DECISION DELEGATED TO HEAD OF PLANNING

Application No:	H09-1089-21	Applicant:	Mr & Mrs C Parker
Proposal:	Alterations, Single Storey Extension and Garage		
Location:	52 Spalding Road Holbeach Spalding		
Terminal Date:	14th January 2022

Drawing,
**ELEVATIONS - EXISTING & PROPOSED
BLOCK & LOCATION PLANS.**

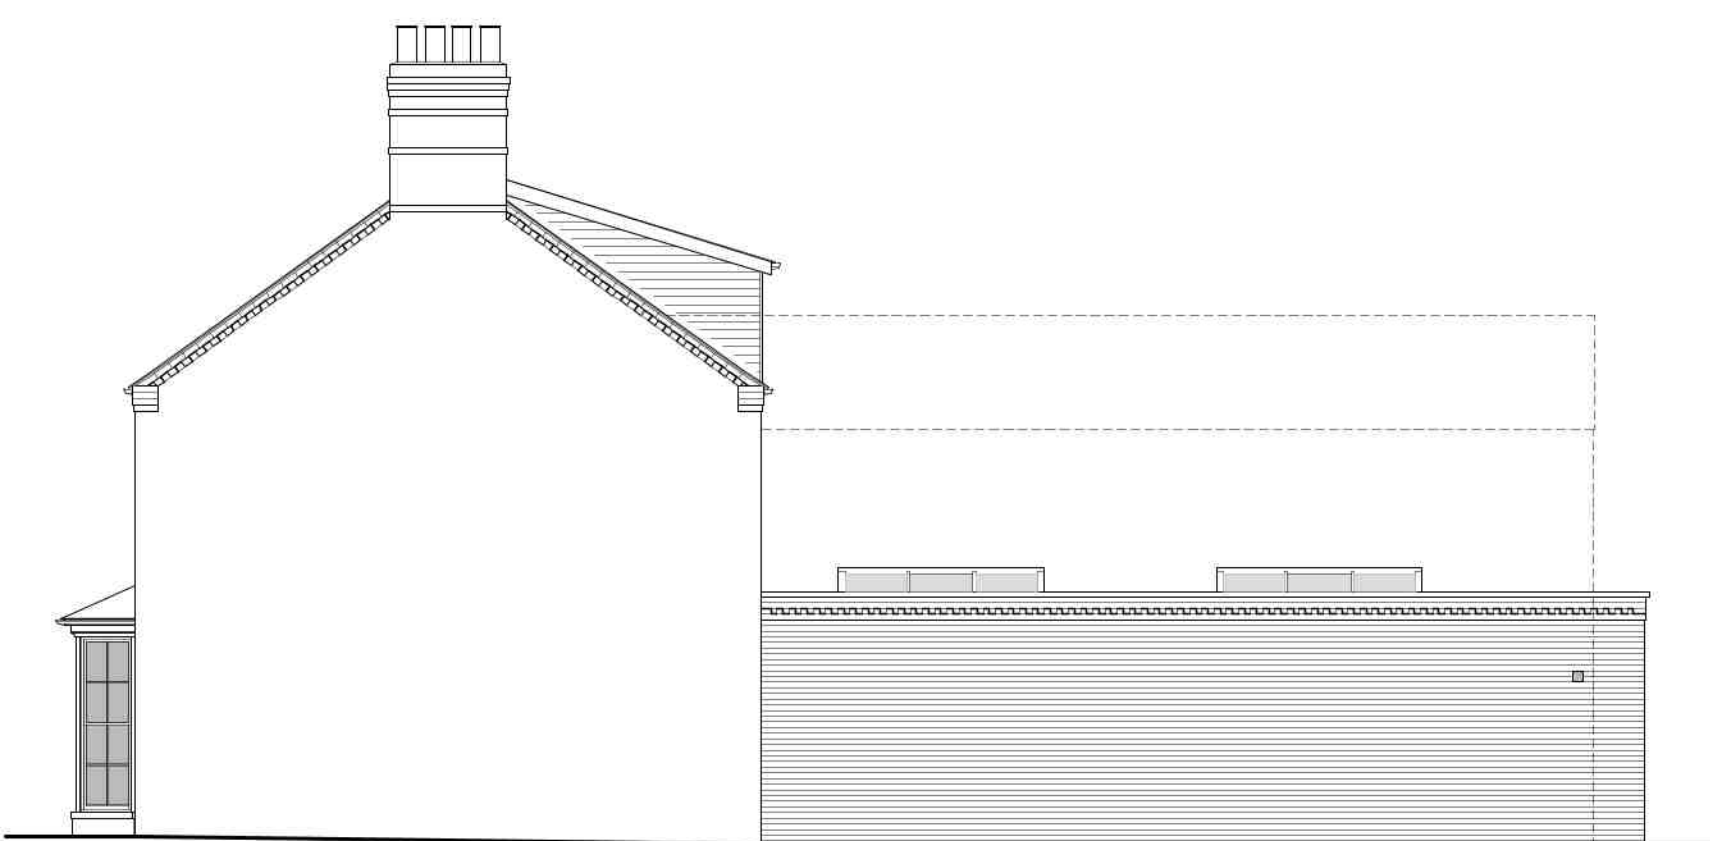
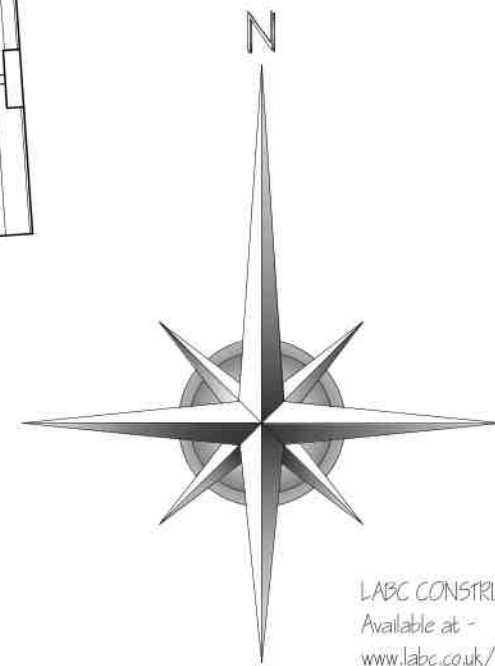
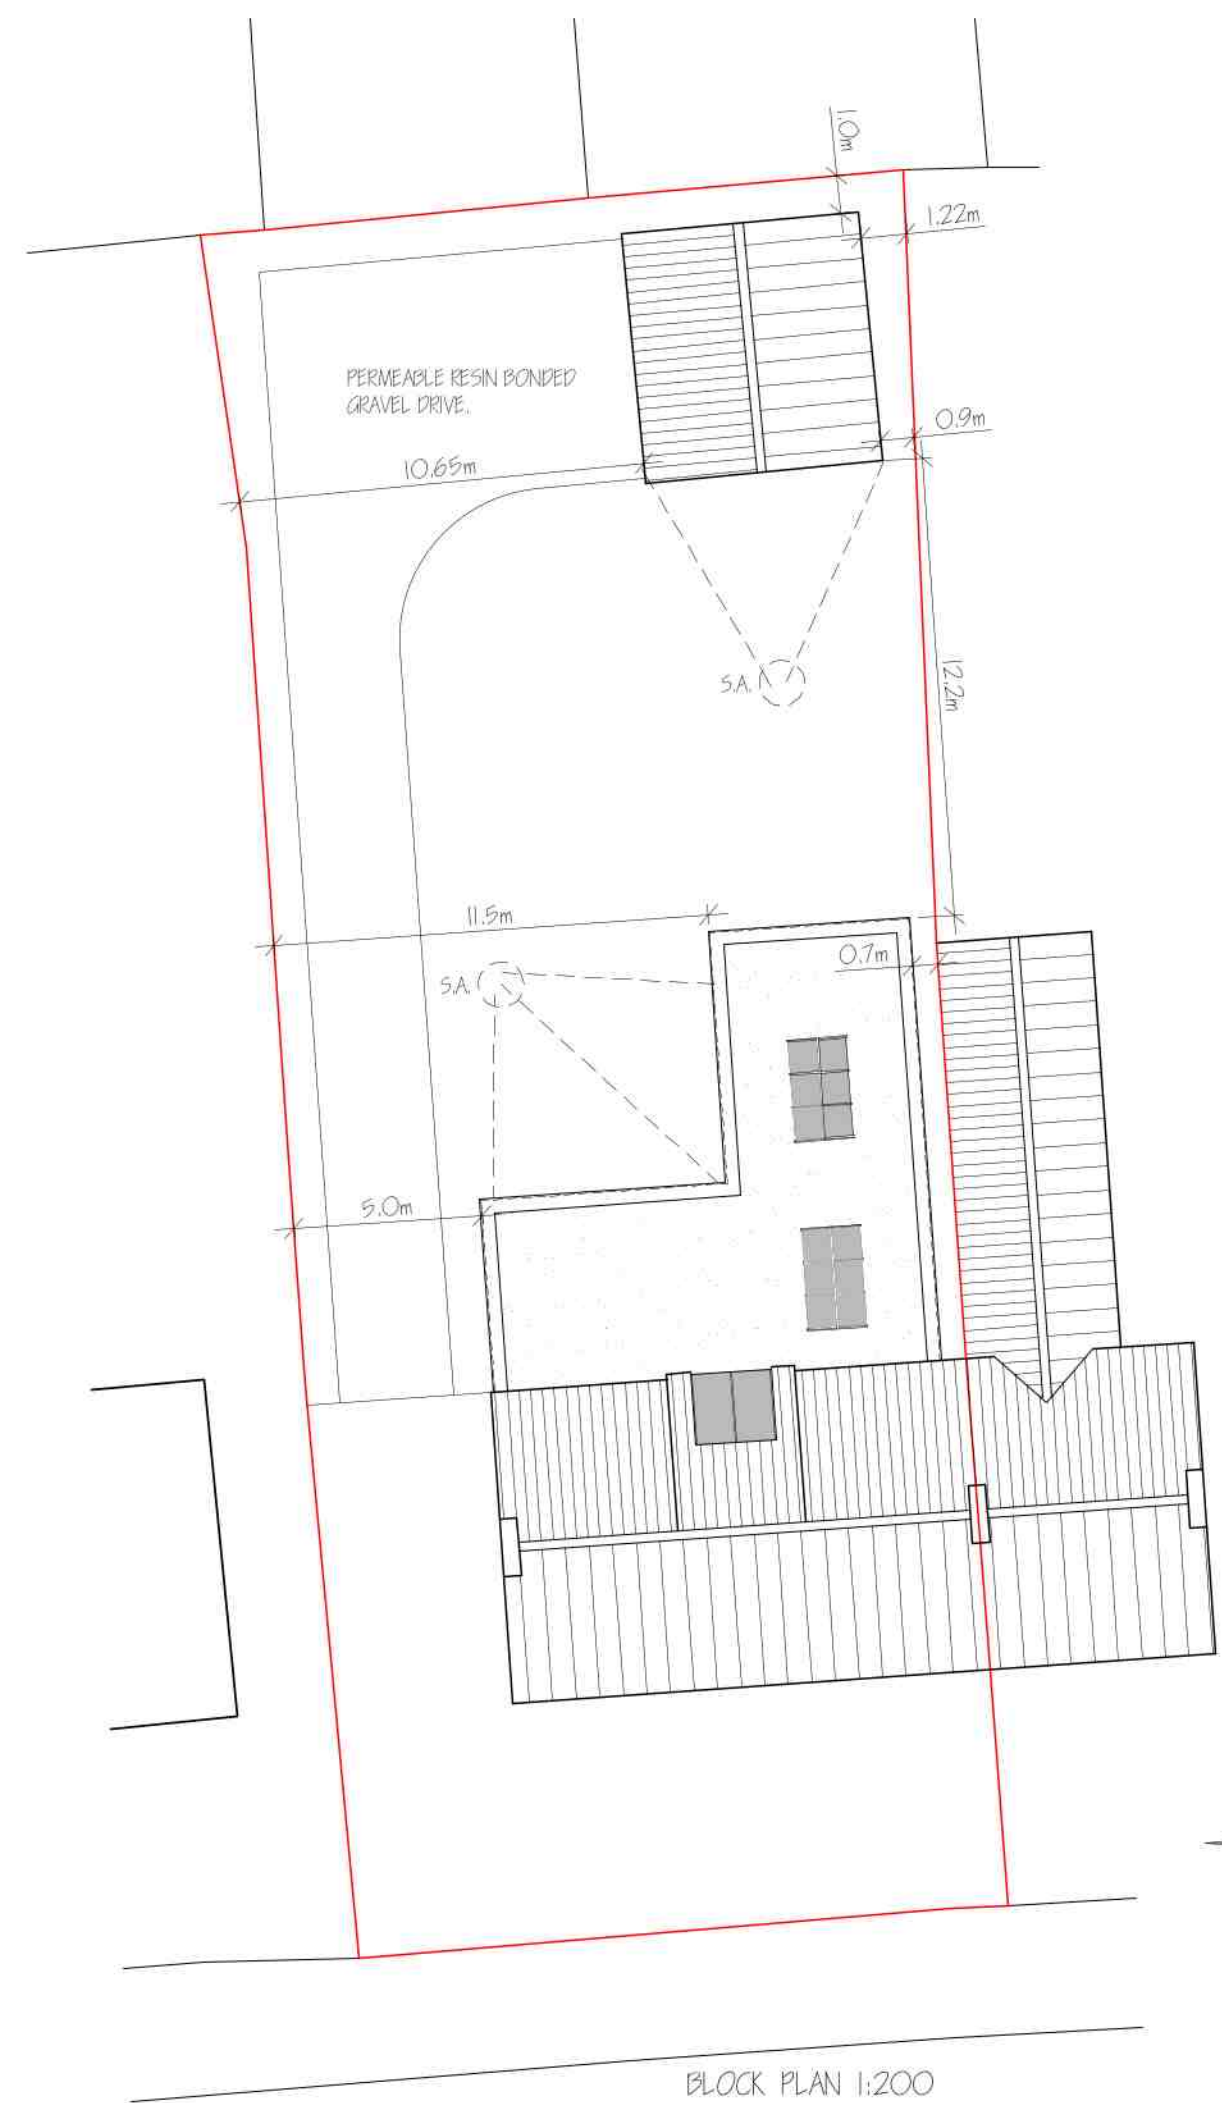
A local resident has objected to the proposal on grounds that it is not in keeping with the area given the depth of the rear extension. The concerns are noted and the depth of the rear extension has been reduced by 5.2 metres. The amended scheme is considered to be a lot more proportionate to the existing dwelling and the site.

It is accepted that the footprint of the rear extensions is quite considerable, however, on balance this can be accepted as sufficient outdoor amenity space would be retained. In addition, the rear projection would be similar to the attached neighbours rear projection therefore the development is not considered to be out of character with the immediate area. Furthermore there would not be any prominent views of the proposed development from the public realm given the extensions and the garage would be blocked by the existing two storey house.

With regards to the neighbour at no.54 Spalding Road located to the west of the application site the proposed house extension would be located at least 5 metres from the shared boundary with this neighbour and the garage would be located some 10 metres away. Given the single storey nature of the proposal and the relationship with this neighbour this separation distance is considered to be sufficient as to not result in any overbearing impact or unacceptable overshadowing.

With regards to the neighbours to the rear, the proposed garage would site close to the rear boundary, however, given its single storey nature and limited height it is not considered that this element would result in any overbearing impact or unacceptable overshadowing. The proposed house extensions would be sited a significant distance from the rear boundary.

The neighbour to the rear has raised concerns that the proposed garage would impact the trees along the rear boundary. The concerns are noted, however, the proposed garage appears to be located a sufficient distance from the rear boundary. In addition, the trees in question do not appear to be of high amenity value therefore it is not considered reasonable to request a tree protection scheme.

It should be noted that the application has been revised and the depth of the rear extension reduced by 5.2 metres.
